Monument Academy
Traffic Impact Analysis
PCD File No. U192/PPR19009
(LSC #184820)
August 16, 2019

RE: Monument Academy
El Paso County, Colorado
Traffic Impact Study
LSC #184820

Figure 2

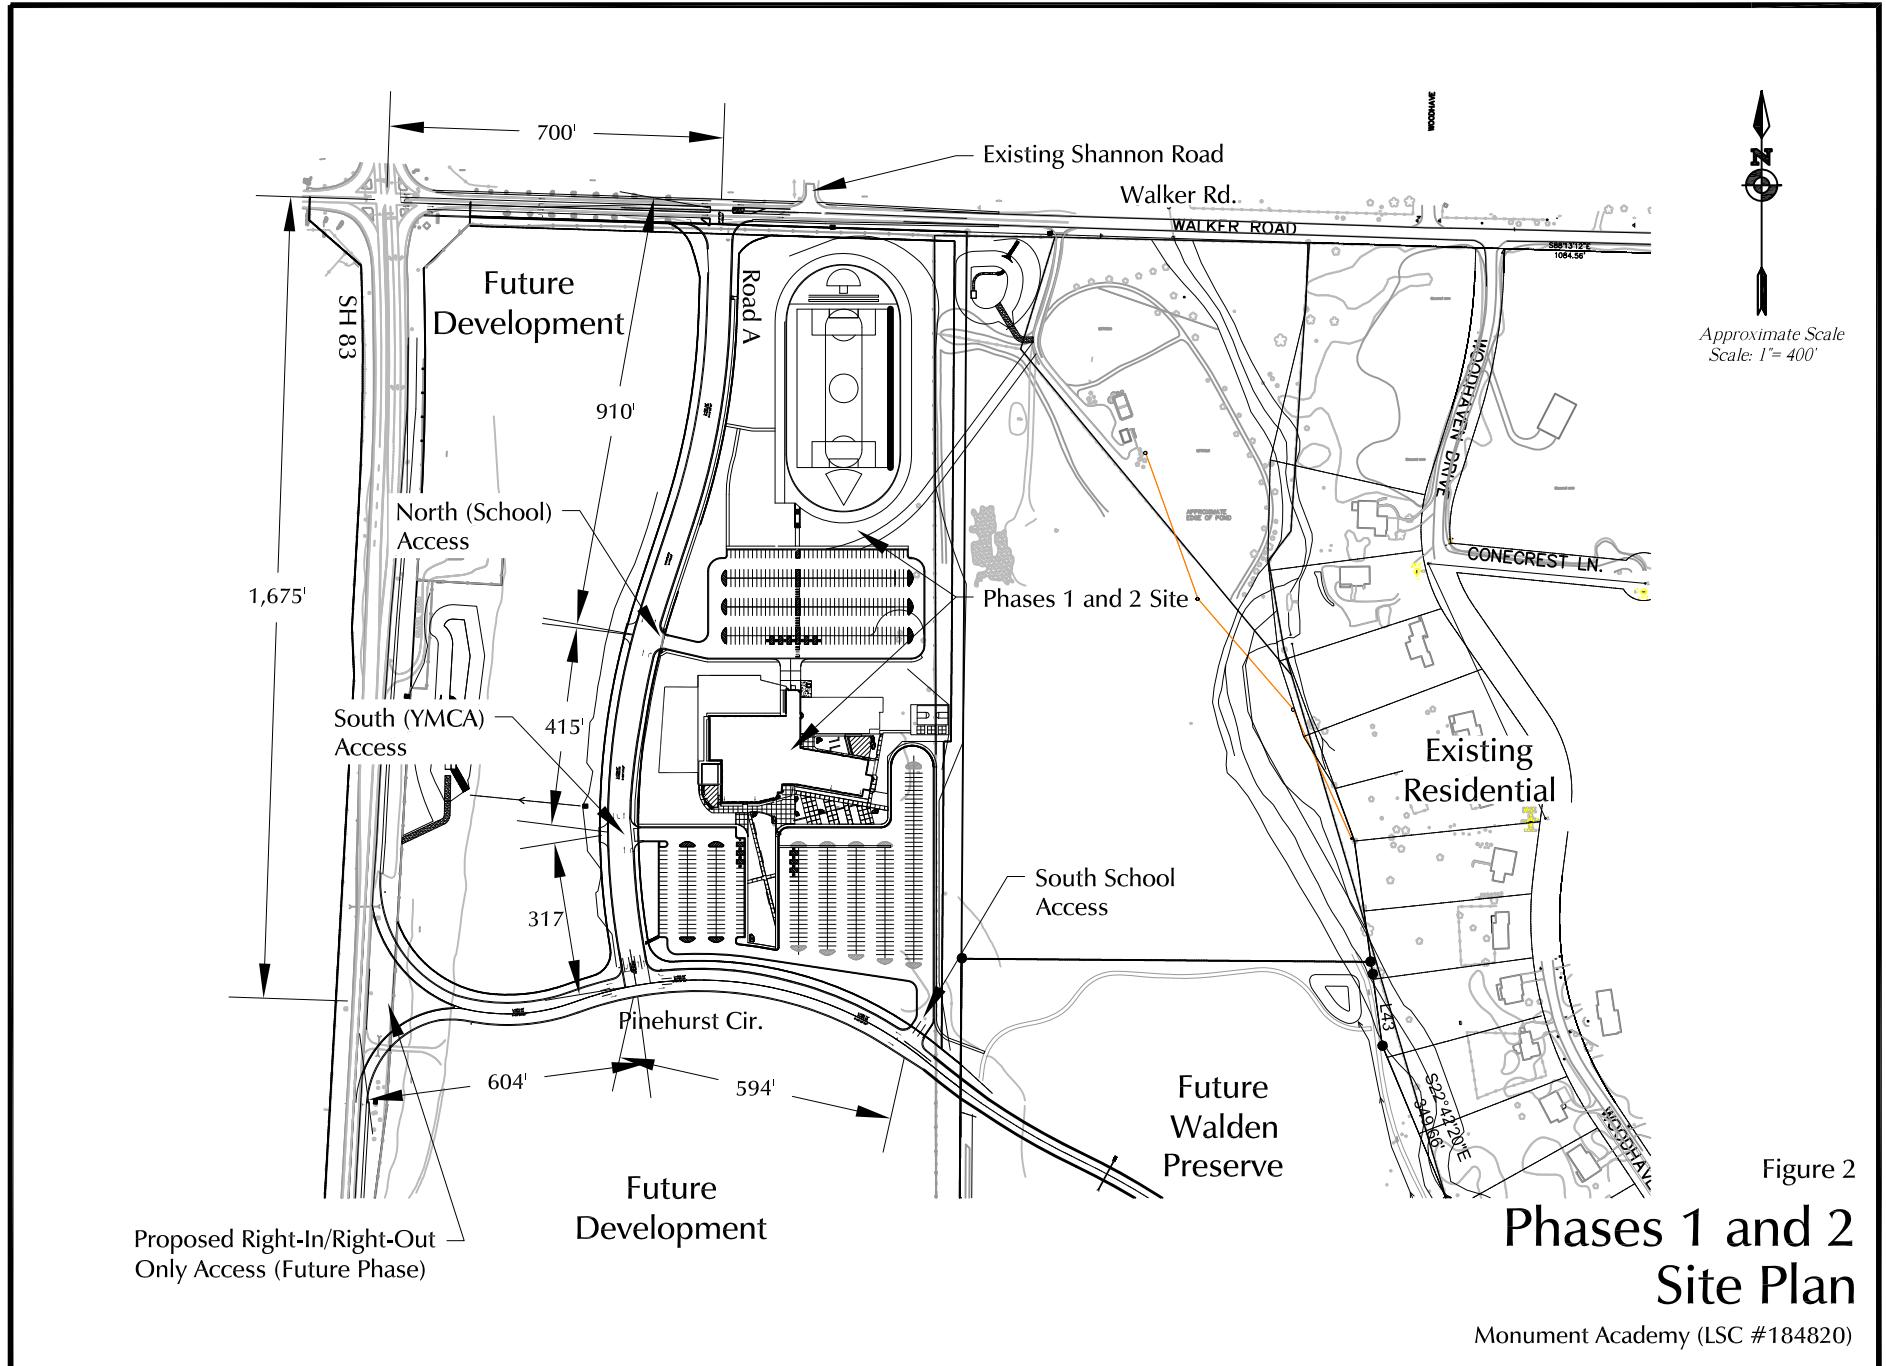
Two full-movement access points are proposed to Road A and one full-movement access point is proposed to Pinehurst Circle. Figure 2 shows the proposed spacing. The spacing of these access points will require a deviation from the *El Paso County Engineering Criteria Manual (ECM)*.

Signage may be utilized within the school parking lot; however, Staff do not see an MUTCD-compliant solution to limit eastbound traffic on the public road.

do not believe access control will be feasible to limit eastbound traffic
